1513911: LGS
Environment & Development Dept.

20 July 2017

Wallerawang Quarry, DA 344-11-2001 Modification 1-Stockpiles and Washing Plant, Great Western Highway, Wallerawang

Figure L1
LANDSCAPE PLANTING

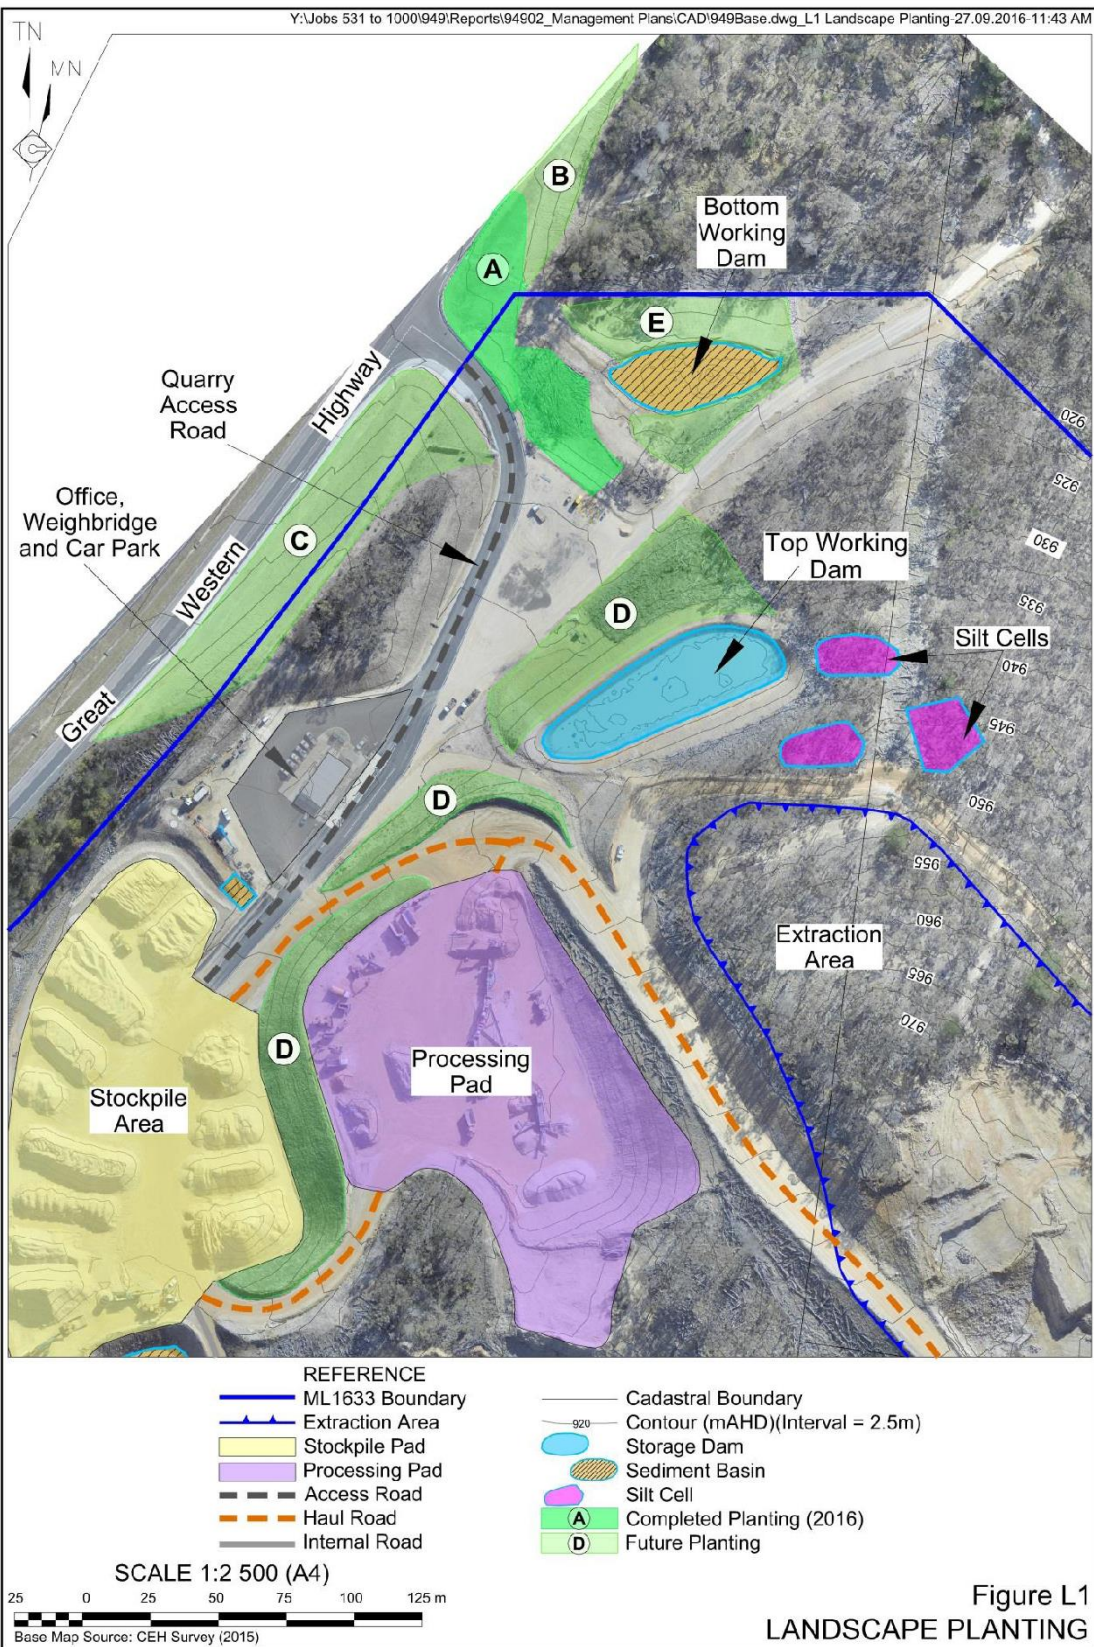
Council previously requested that more consideration is given to the visual impacts from the Great Western Highway to the Quarry site, specifically in relation to the timeline as to when the vegetation would be planted and the construction of the bund wall.

A timeline is yet to be submitted with the response. As such Council is unable to undertake an adequate assessment of the application until the information that Council previously requested has been submitted.
